**From:**  
**Sent:** 31 December 2024 15:00  
**To:** DC Admin  
**Subject:** PLANNING APPLICATION 2024/93341

### **Planning application 2024/93341\_Erection of extension to detached garage block, raising of roof height and erection of front dormer, with associated alterations at 54 Wellhouse Lane, Mirfield WF14 0PW**

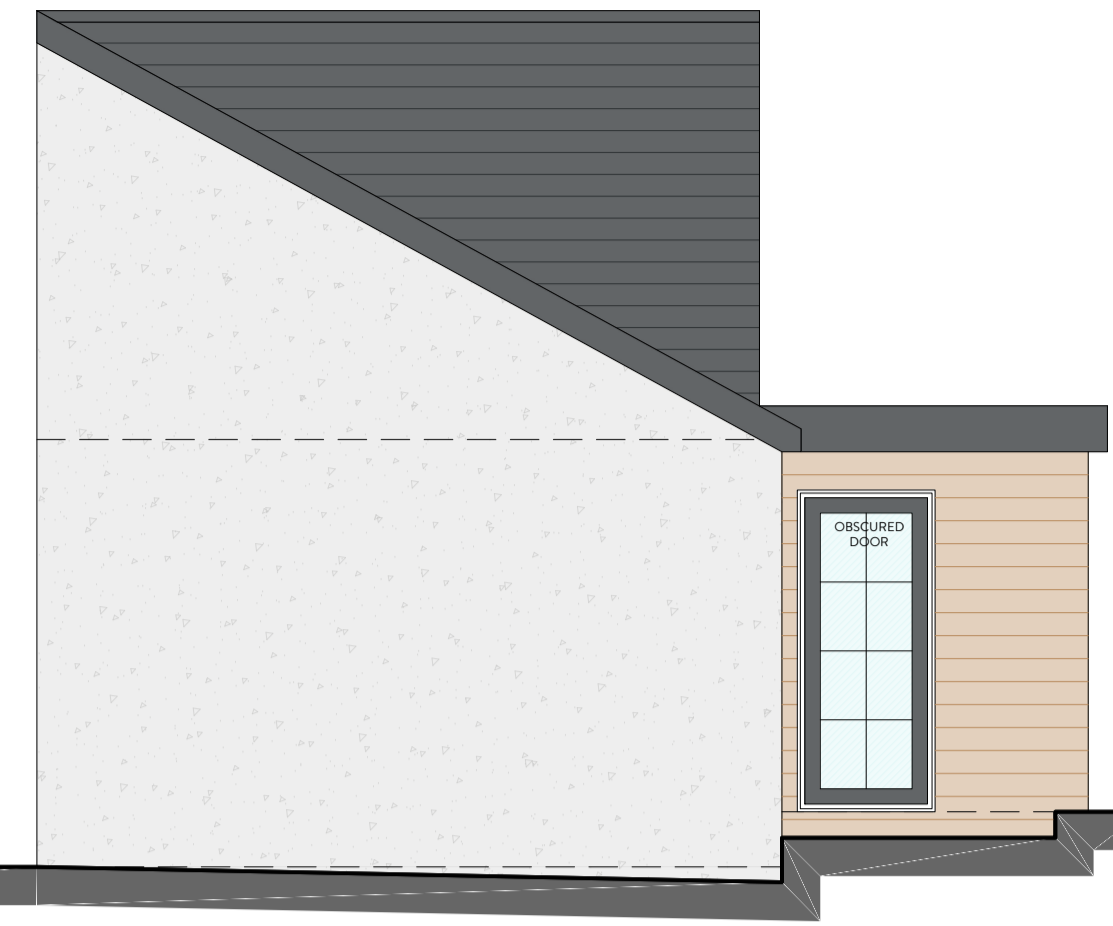
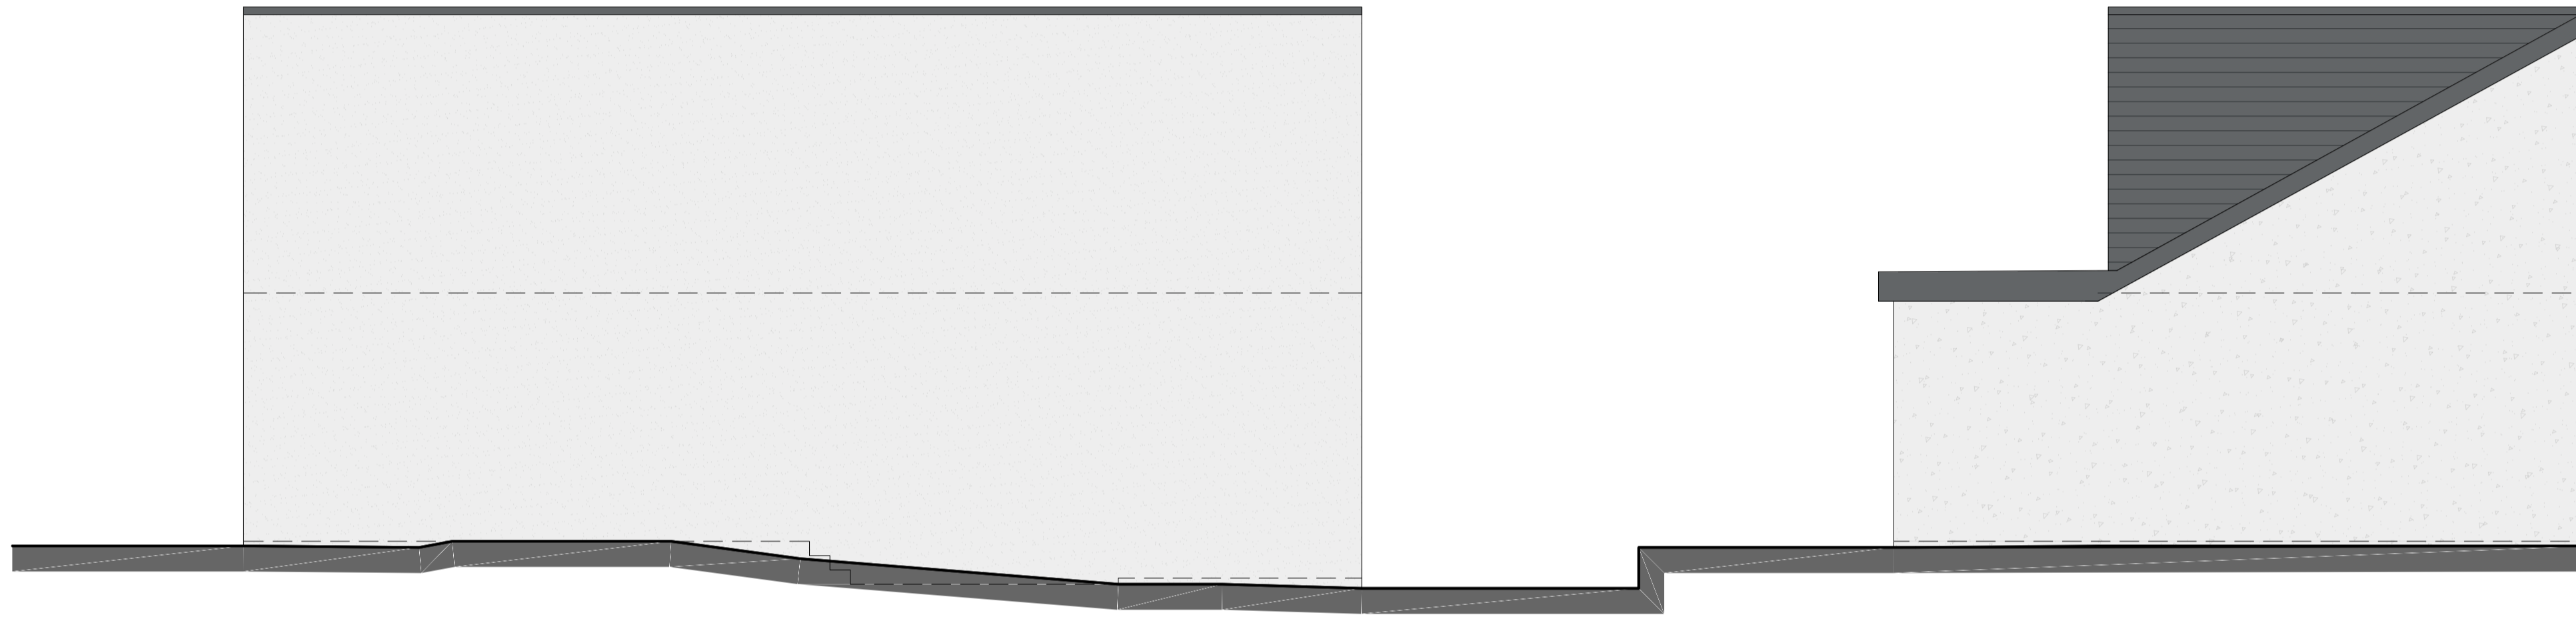
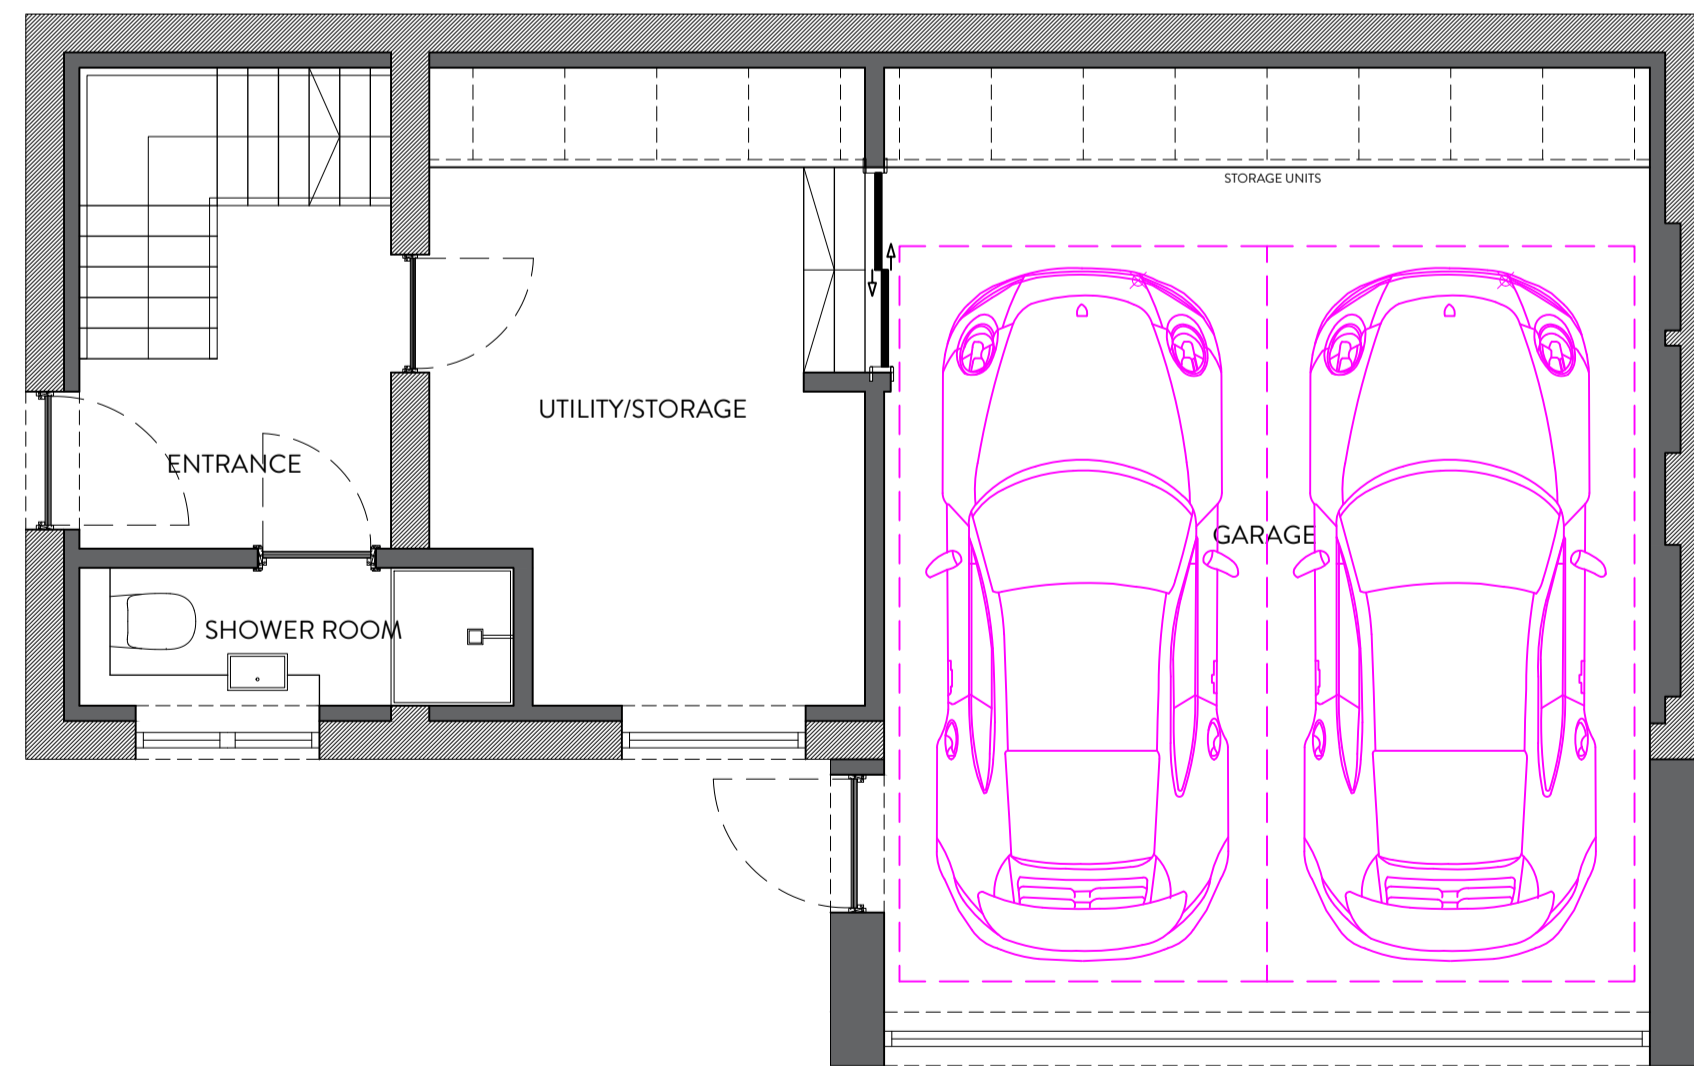
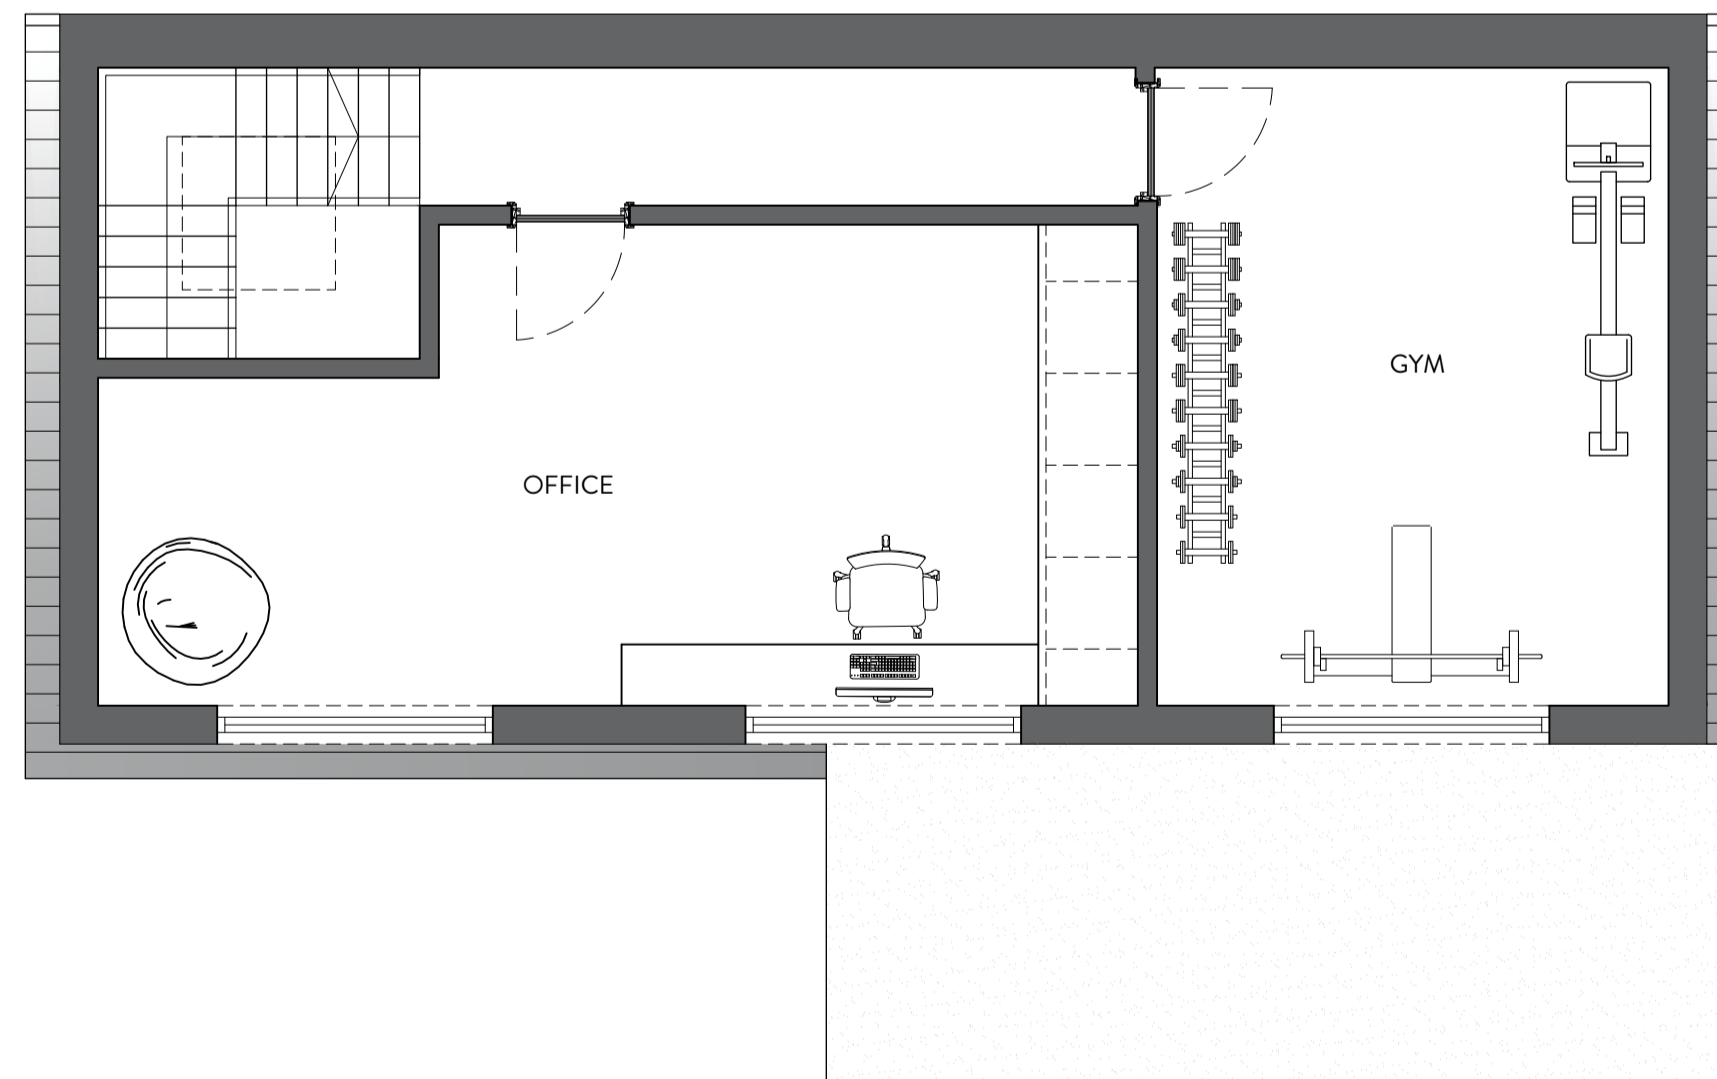
The proposed general arrangement drawing shows increased capacity for vehicles near and obstructing the gateway of number 54A, access to the garage would block the gateway temporarily, the property has a covenant listed in the deeds that prevents this.

The increased roof height of the proposal to a two-storey outbuilding will be very detrimental to no.6 Woodward Court on the North side and will impact greatly on the primary habitable windows both downstairs in their kitchen and upstairs from the master bedroom. The distance from their home to the elevation is less than 6 metres. In addition, the O/S map submitted by the applicant shows no.6 incorrectly positioned the original builder moved the house 4ft further to the left to line through with another property bringing it directly in line with the garage's north elevation, not offset as the plan shows. Another concern is the different land levels, Woodward Court is on higher ground approximately 3ft. The occupants fear a landslide once the original north elevation is removed, damaging their garden and potentially causing foundation damage to their property. These factors are unacceptable and as a result the application should be refused.
